Addendum No. 2

RE: Contract # C204286

Haywood County (I-5922, I-5923)

I-40 FROM THE TENNESSEE STATE LINE TO MP-15

PROJECT REFERENCE NO.		SHEET NO.
I-5922	I-5923	2A-1
STATE PROJECT	F.A. PROJECT NO.	DESCRIPTION

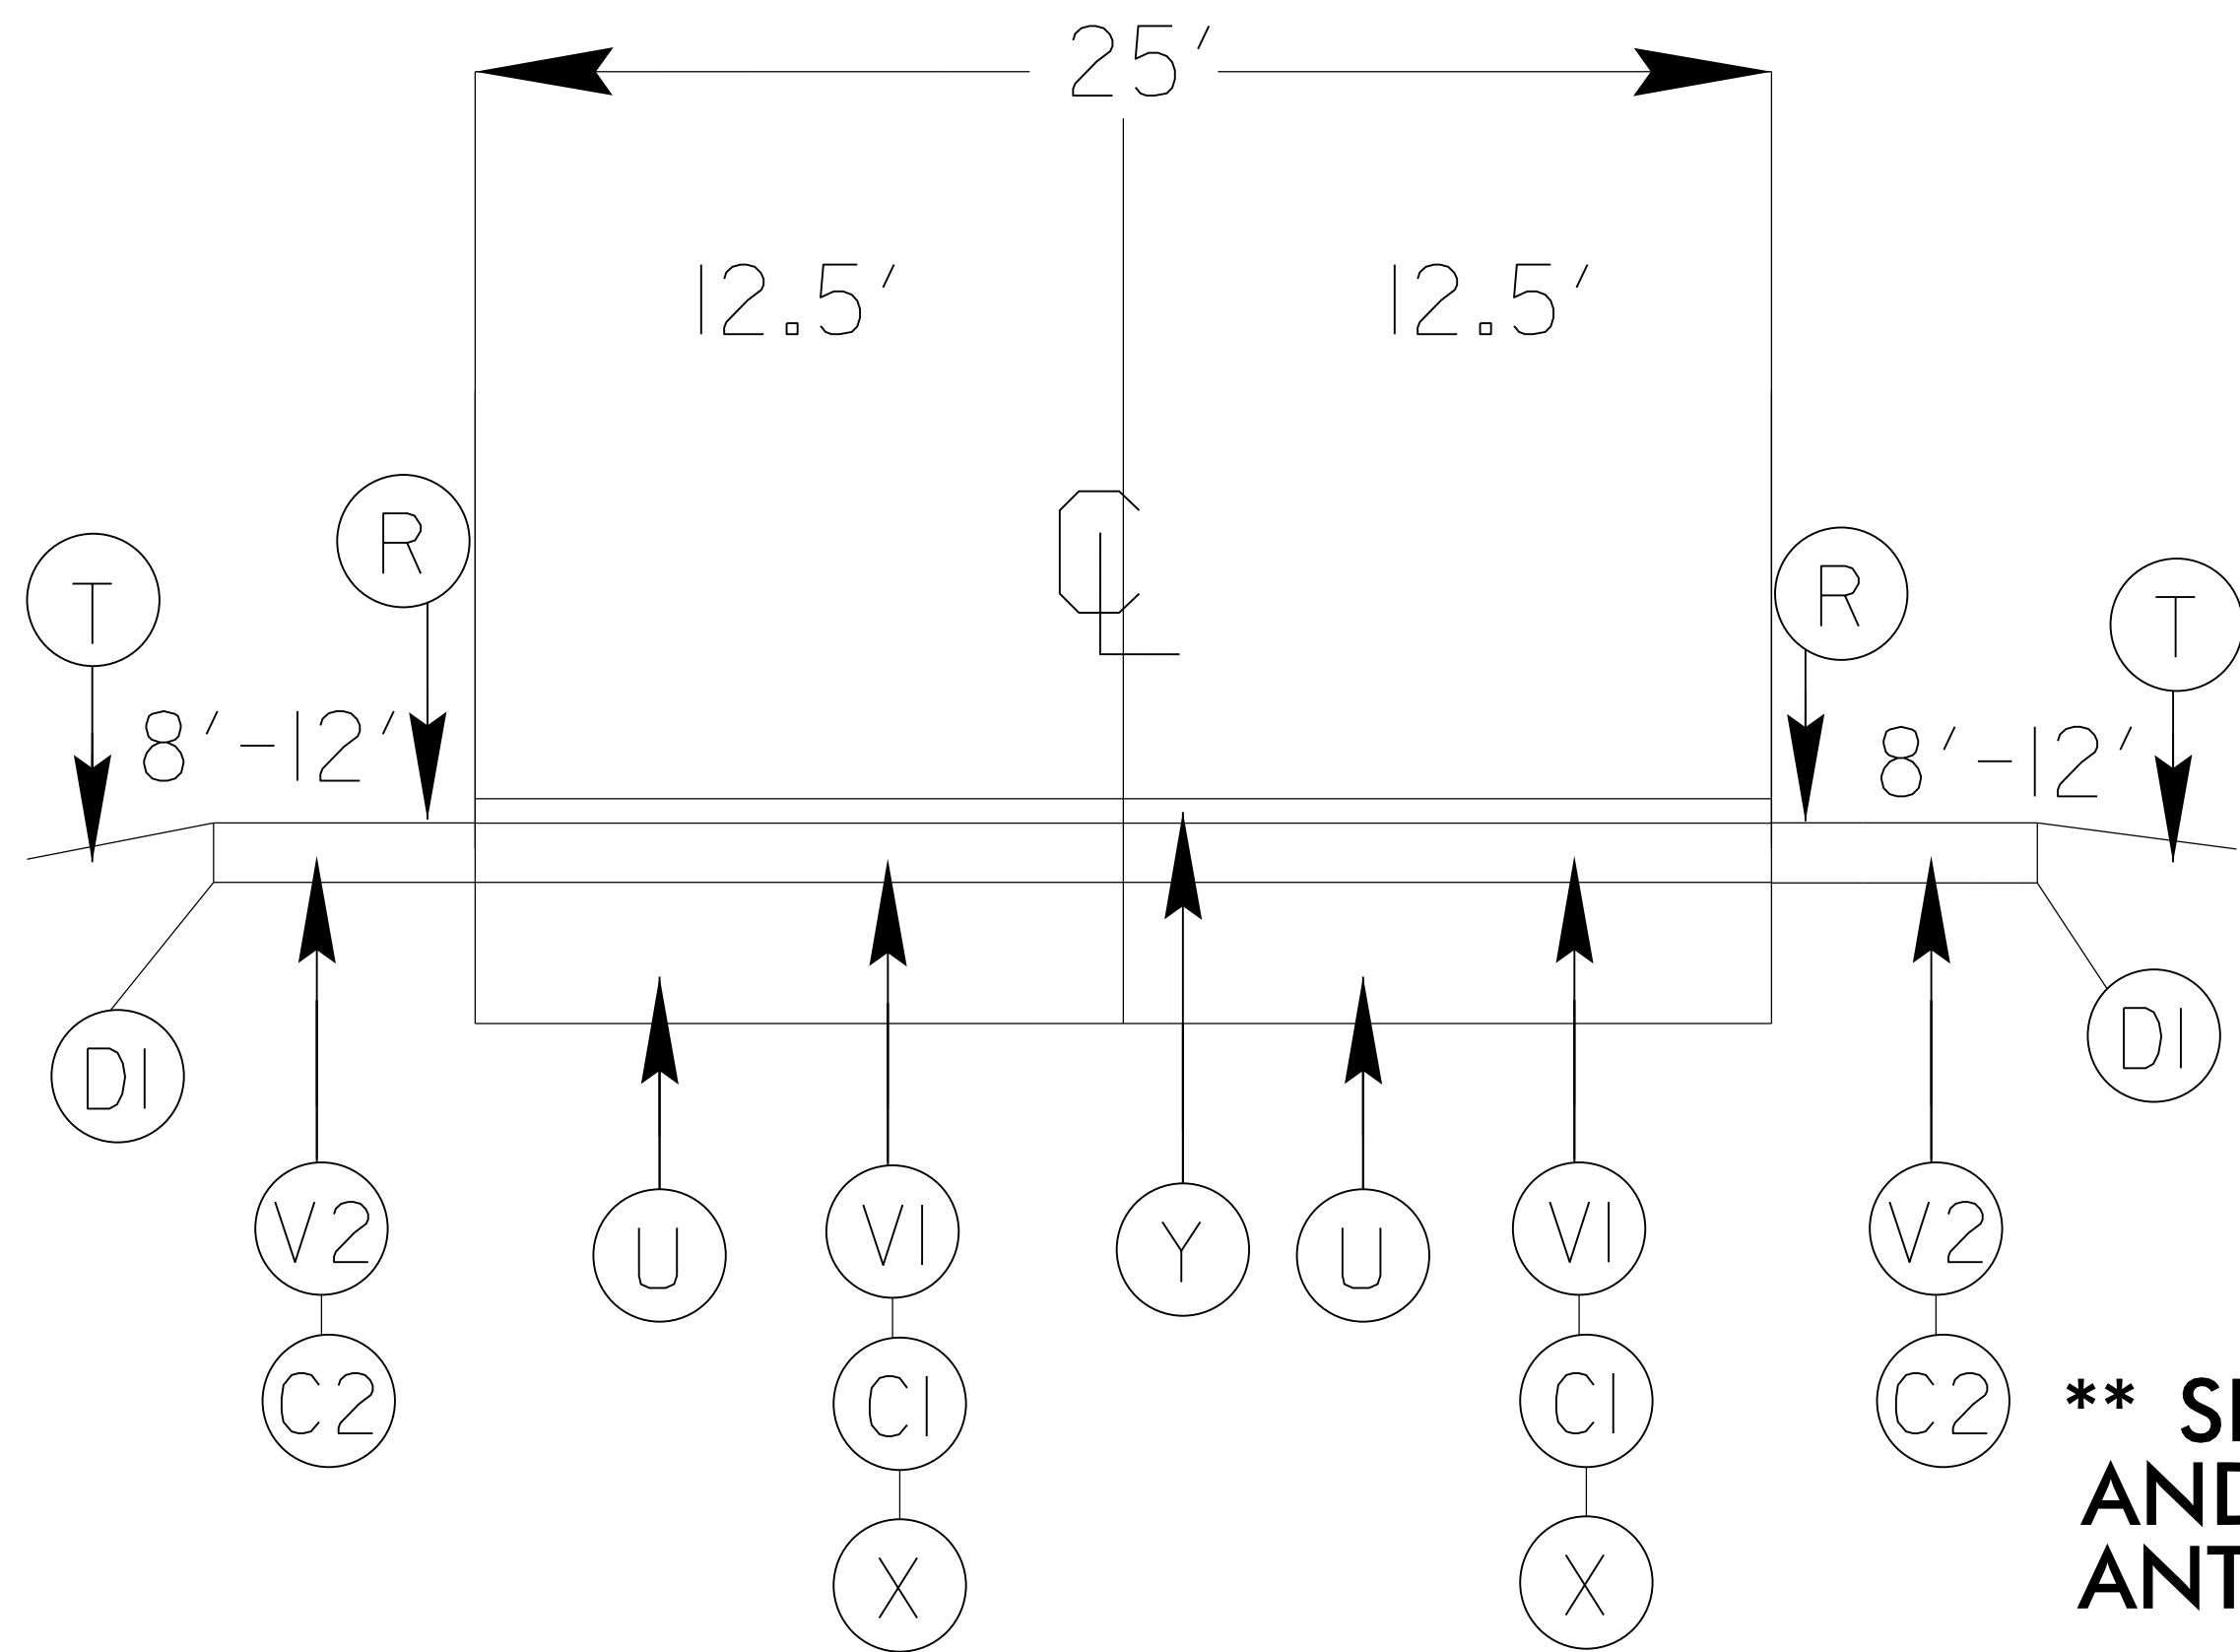
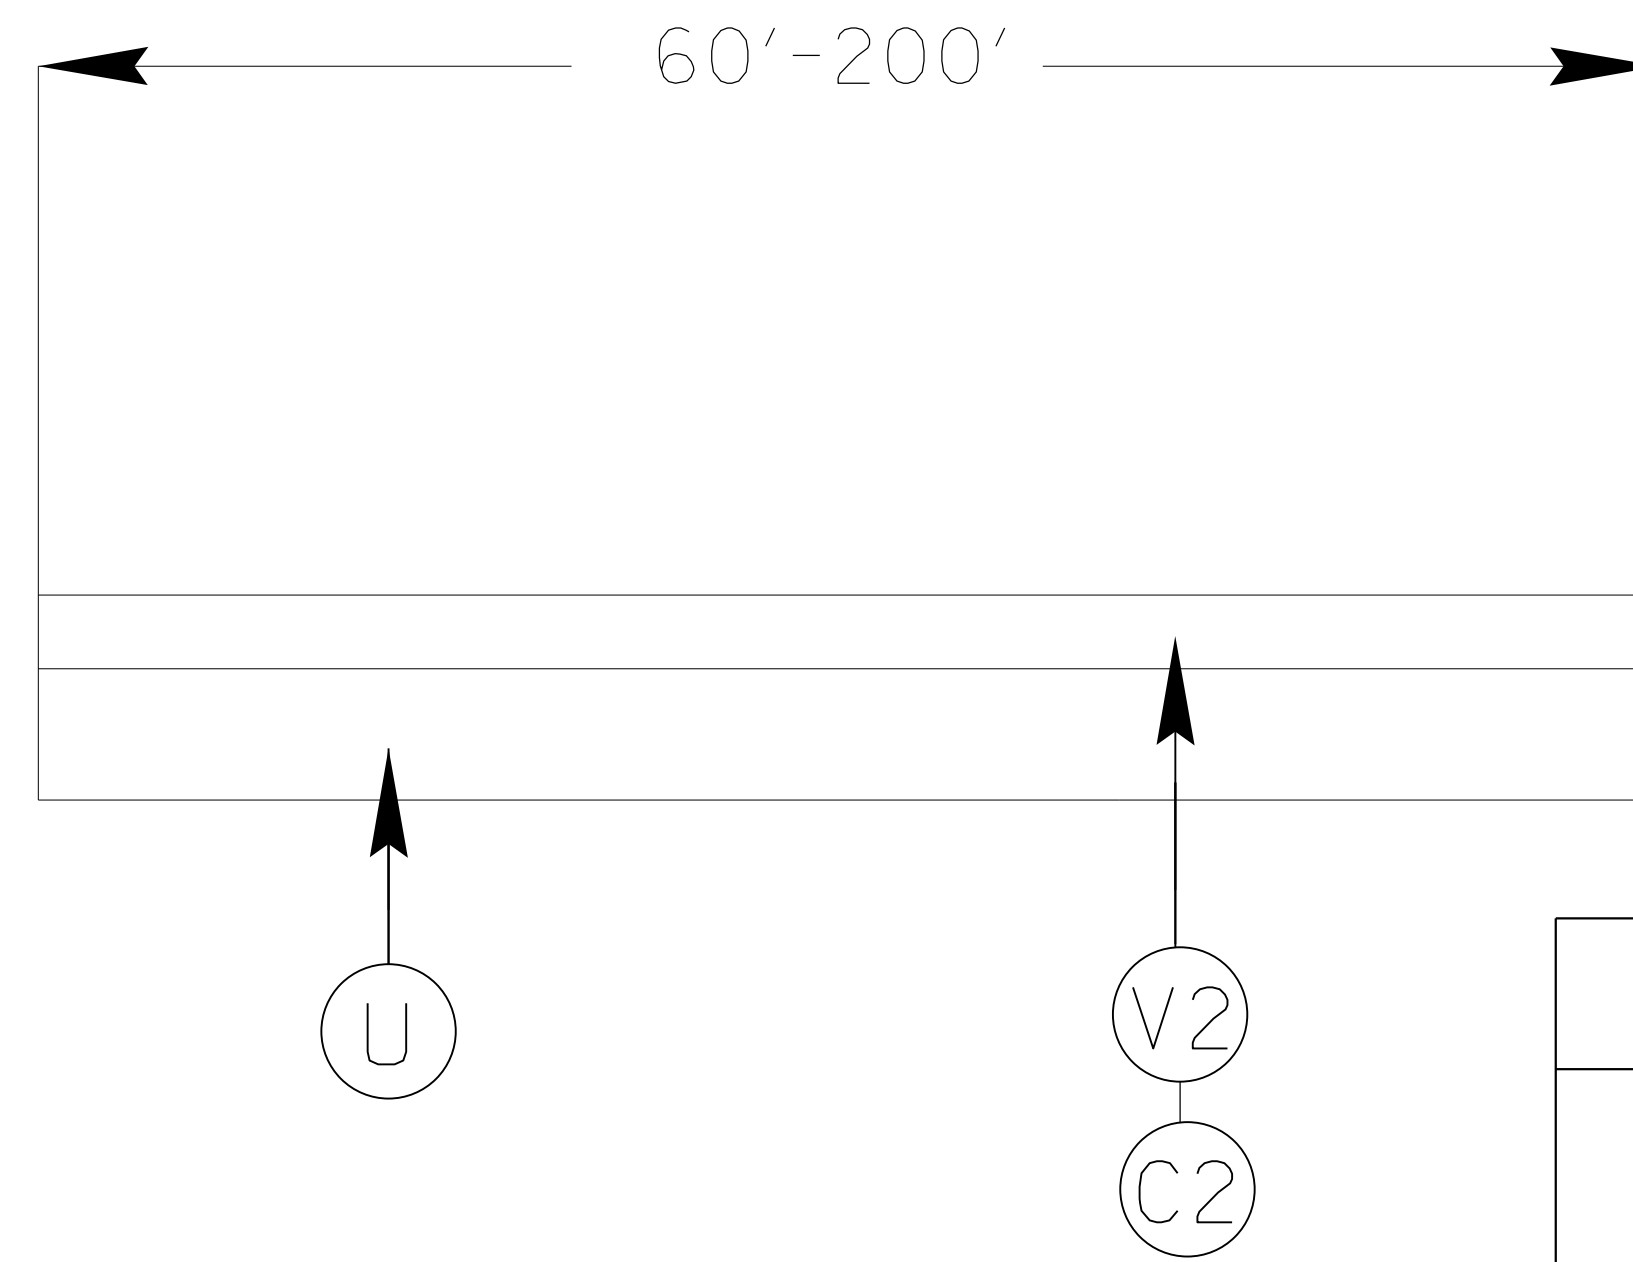
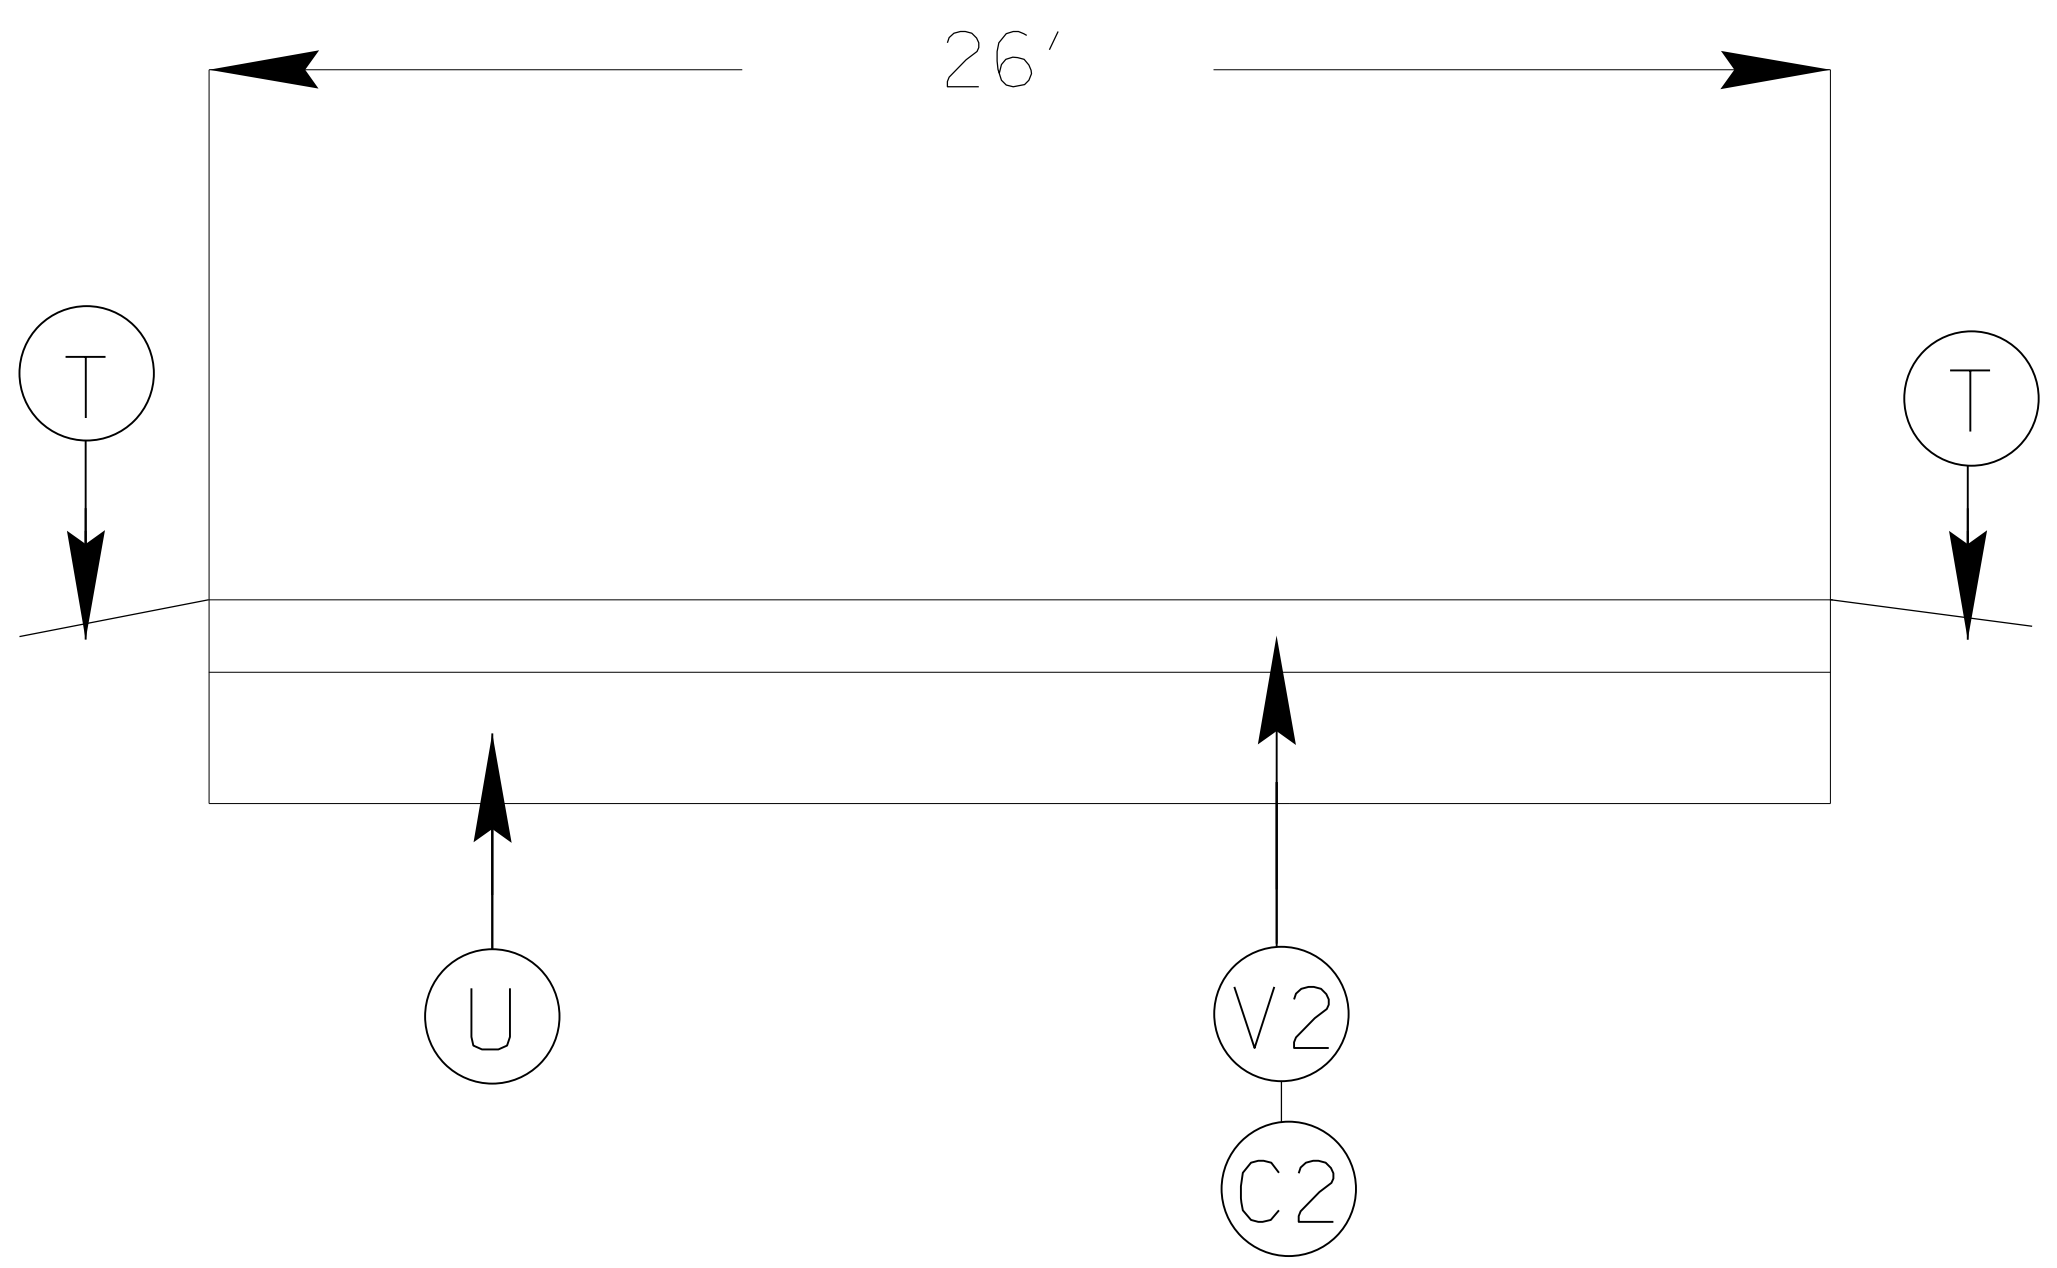
Sheet No.	Revisions
4	Note added to clarify areas of 0" to 1-1/2" Milling and revised quantity for Portable Queue Warning System in Summary of Quantities.
